Arun District Council
Arun Civic Centre
Maltravers Road
Littlehampton
West Sussex BN17 5LF
Planning & Building Control General Enquiries
Tel: (01903) 737756 Fax: (01903) 730442
Dx: 57406 Littlehampton
Minicom: 01903 732765
e-mail: planning@arun.gov.uk
website: www.arun.gov.uk/planning

Application No: BE/143/21/HH
Site Address: 19 South Way Bersted PO21 5HB
Description of works: Removal of existing three lean-to structures and erection of single storey side and rear extension.

Thank you for your internet representation made on 3rd November 2021 which has been recorded as an objection with the comments as follows:

sheet 1 b of 3

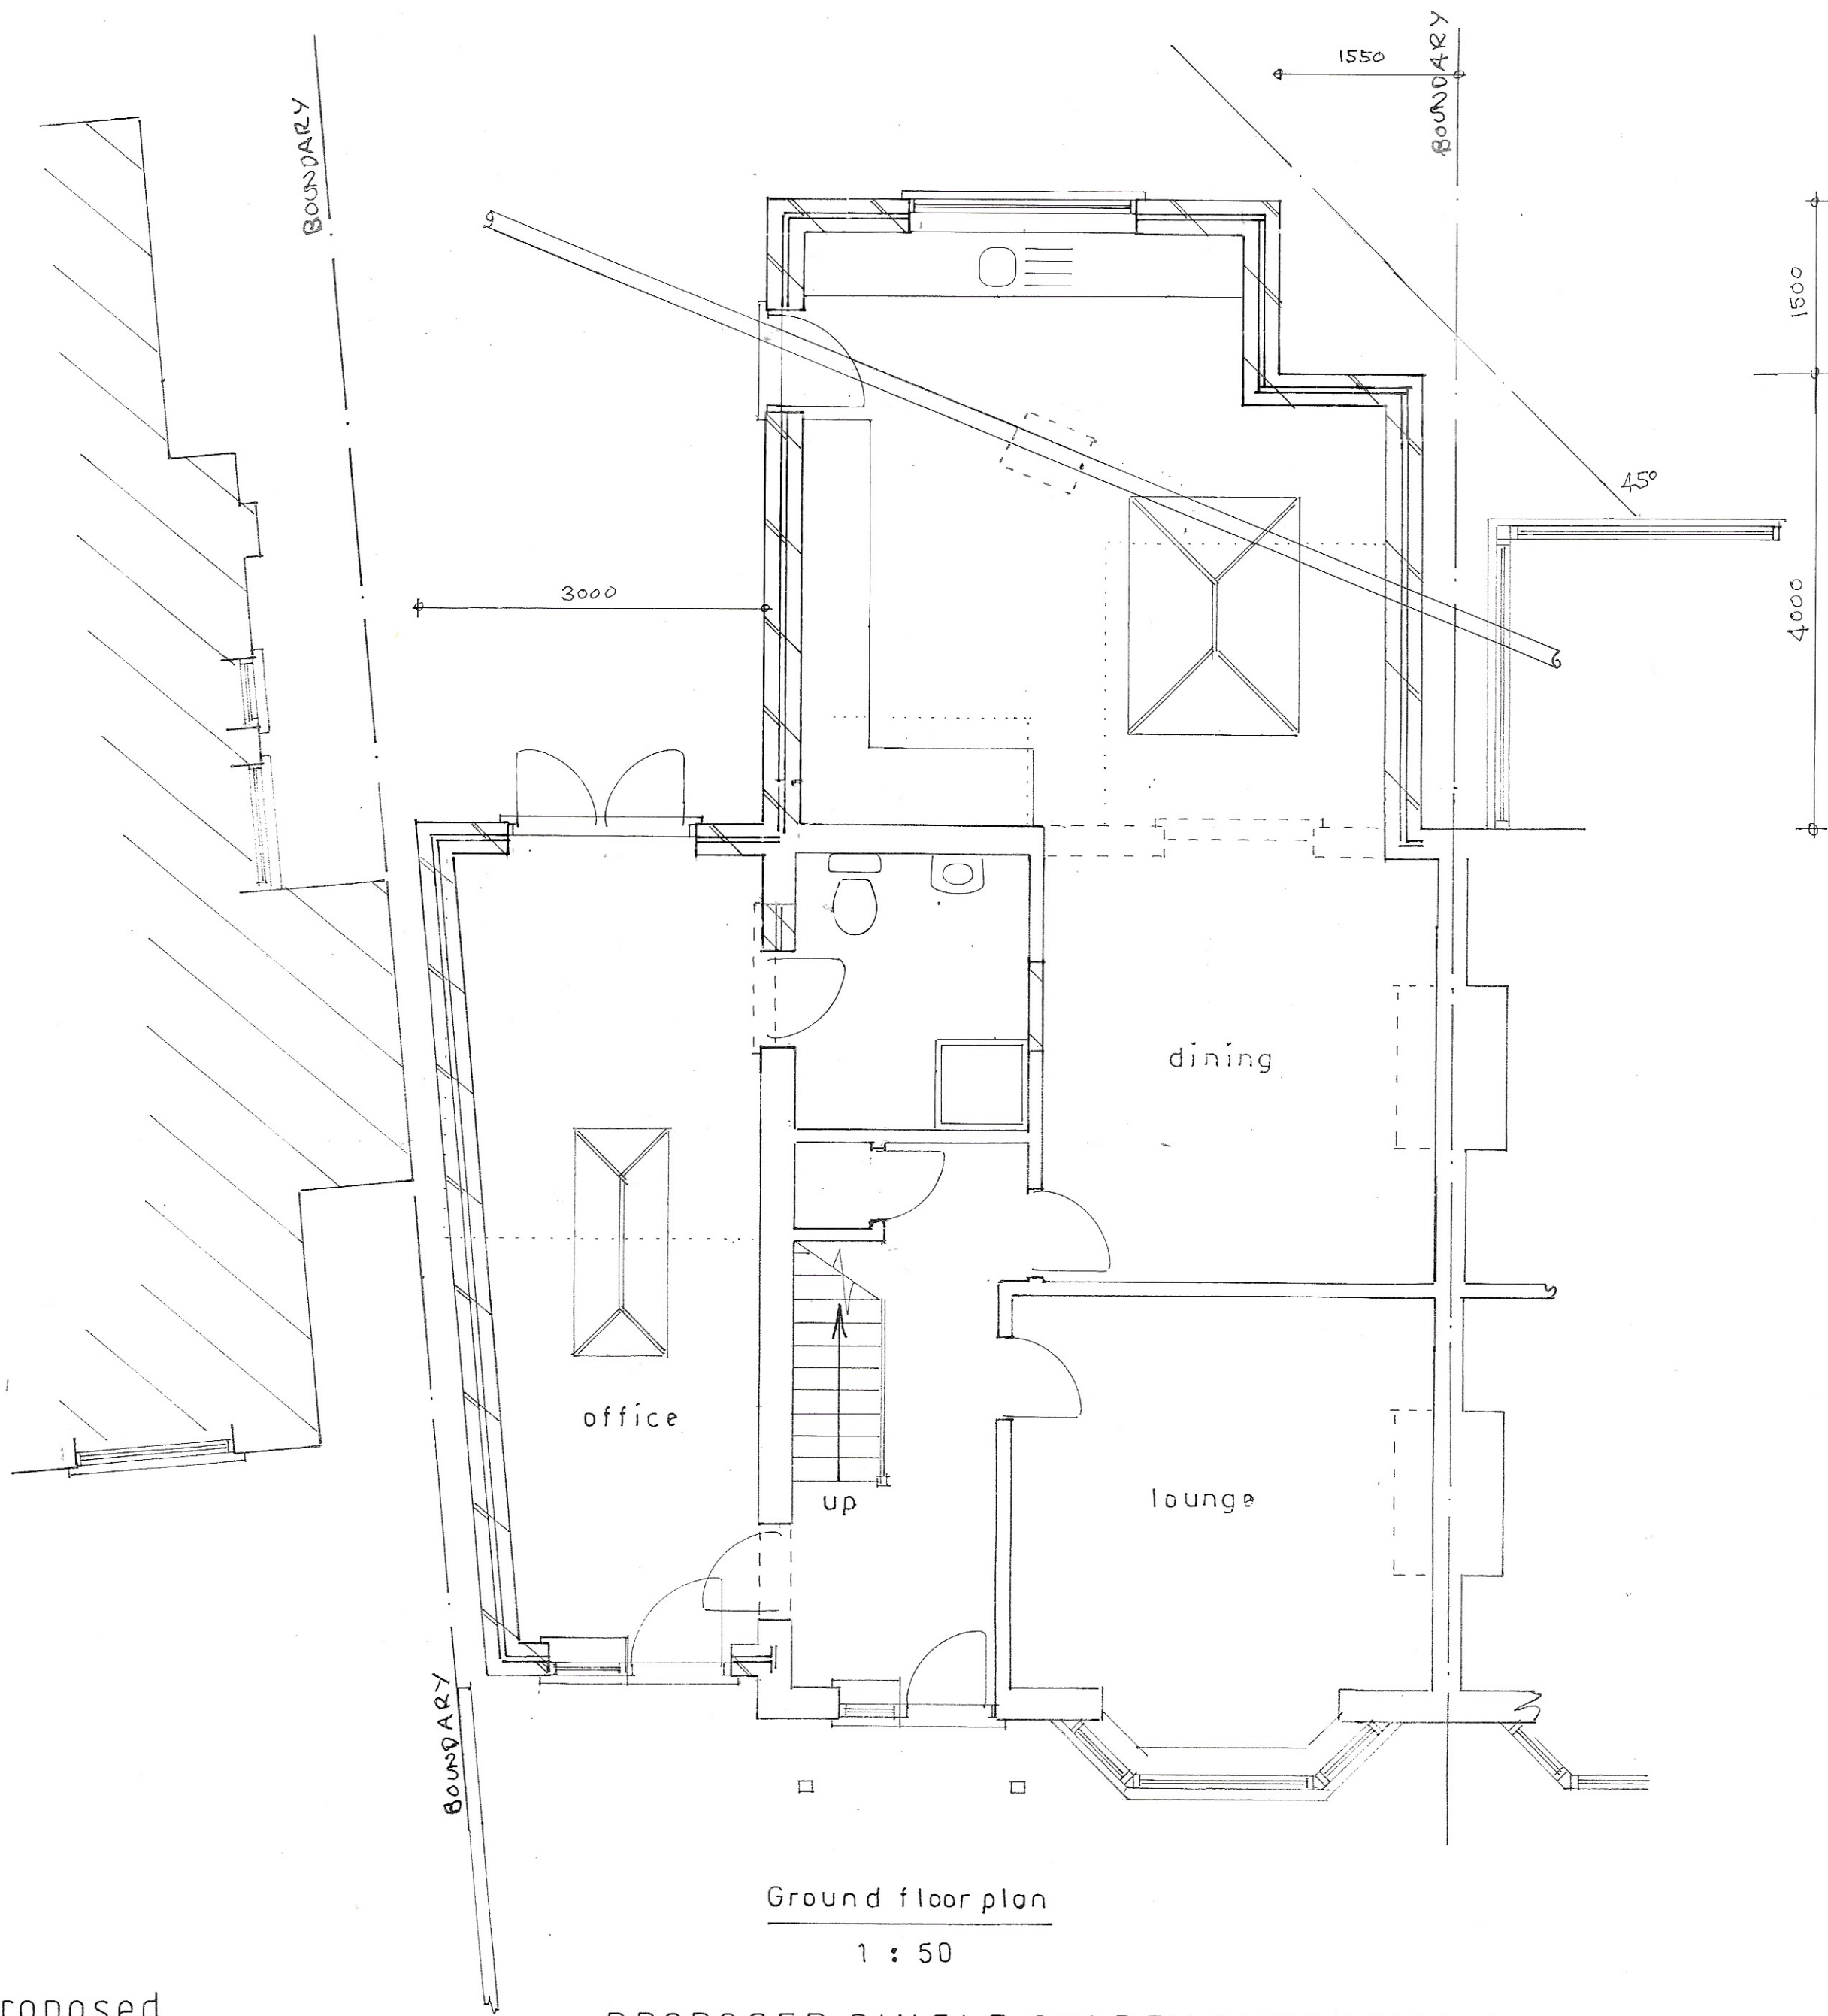
Looking at the revised plan I fail to see why an office is needed in a residential property and why a toilet/shower room is needed off of the office room. This would suggest that the room is to be used as a bedroom rather than an office. There is still no provision for extra parking at this address, this is obviously a HMO and this office/bedroom will make it a 6 bedroom house, which is double the amount of bedroom of the surrounding properties, which will make parking a major concern as this property is on a bus route and is a major access road to two local schools.
